Application Ref:	3/2026/0207			 Ribble Valley Borough Council www.ribblevalley.gov.uk				
Date Inspected:	01/04/2026	Site Notice:	01/04/2026					
Officer:	MC							
DELEGATED ITEM FILE REPORT:					APPROVAL

Development Description:	Proposed change of use from taxi office (Sui Generis) to children's role play centre (Use Class E(d)) including ancillary cafe (Use Class E(b)).
Site Address/Location:	29-33 Berry Lane, Longridge, PR3 3JA

EXISTING AND PROPOSED PLANS
 LITTLE LONGRIDGE ROLE PLAY TOWN, UNIT D, 29-33 BERRY LANE, LONGRIDGE, PR3 3JA

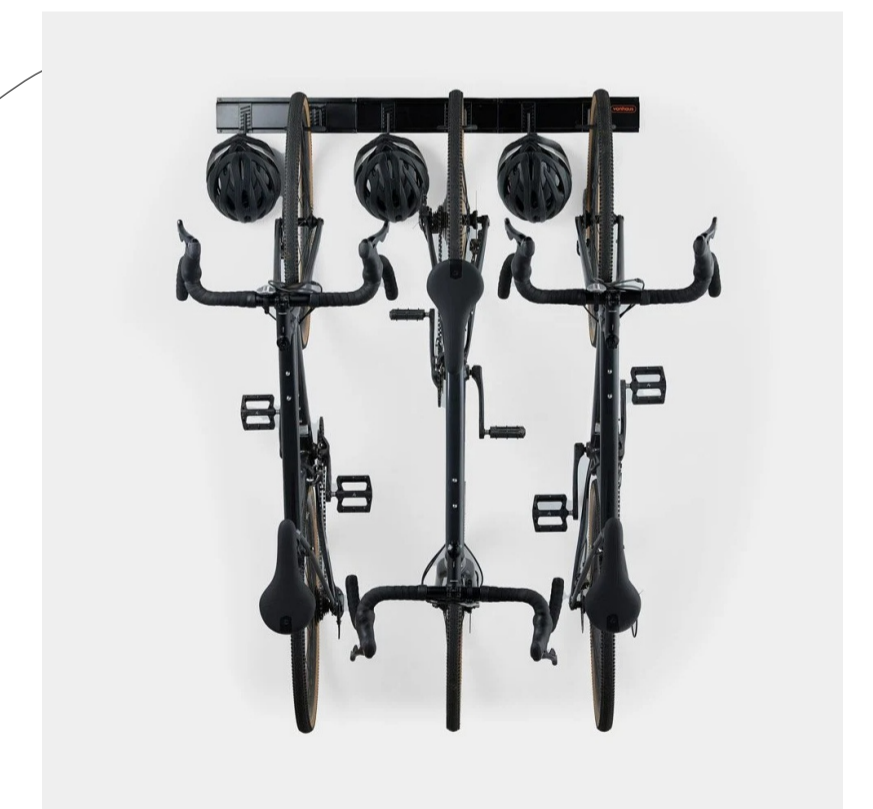
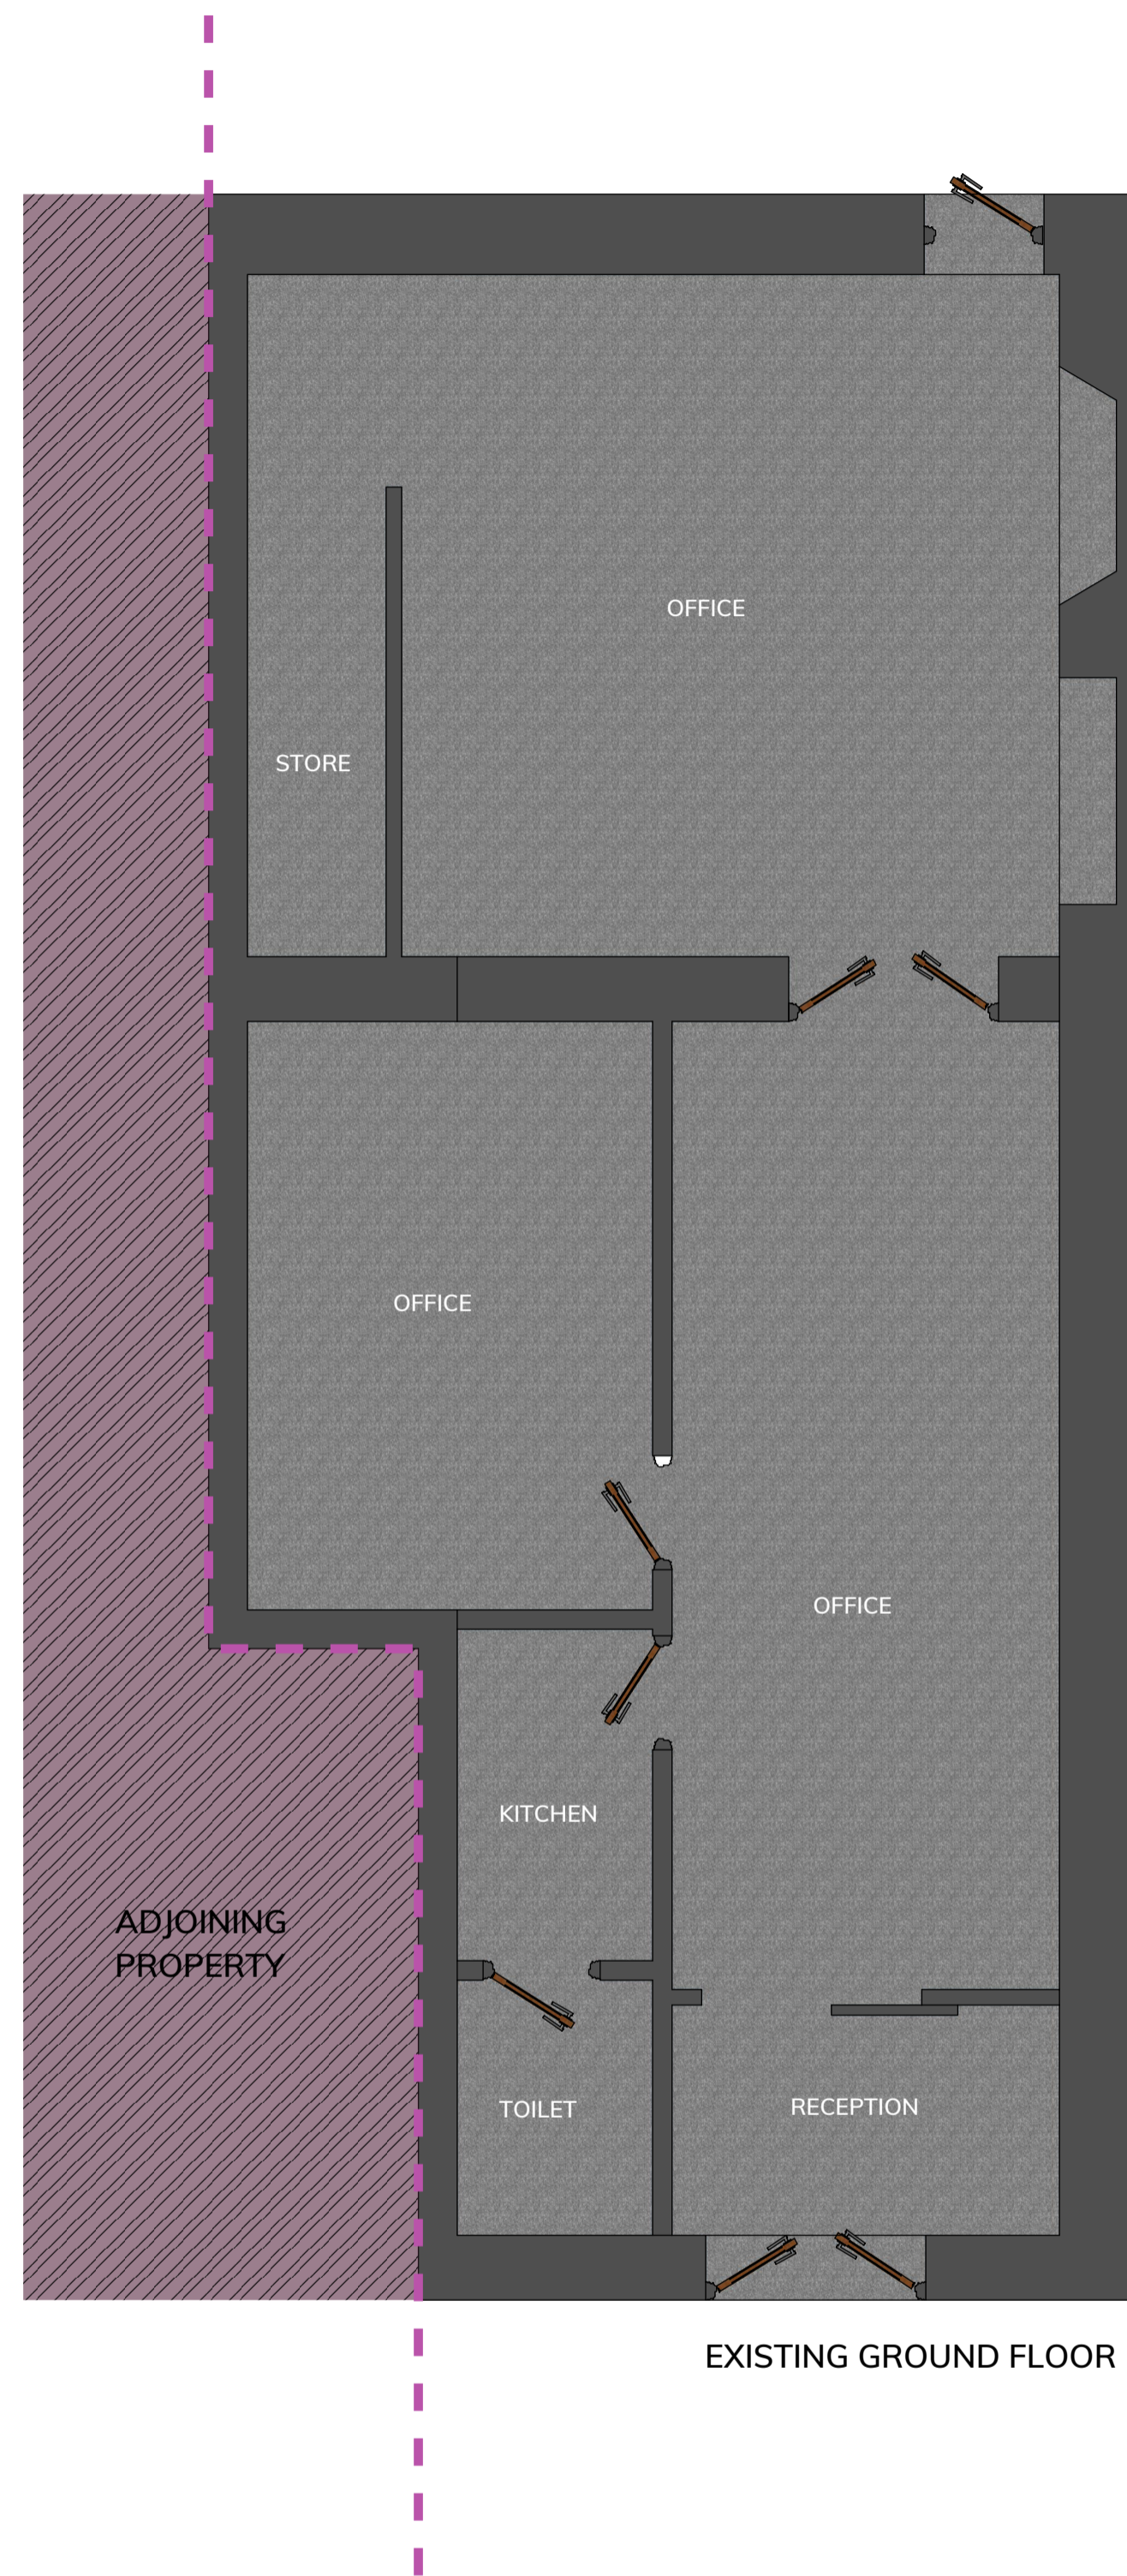
The site is located in a sustainable location, in the centre of Longridge with access to frequent bus services for customers to access the site by public transport. In addition, cycle storage could also be provided to the rear of the property to encourage sustainable travel (as suggested by the Local Planning Authority).

The bin store would be contained within the rear of the building and the bike storage would be within the main building itself. As such, the proposal is considered to be acceptable and would have a neutral impact on the character and appearance of the Longridge Conservation Area and the Non-designated heritage asset.

Cycle storage has now been provided within the building and this can be secured by way of planning condition.
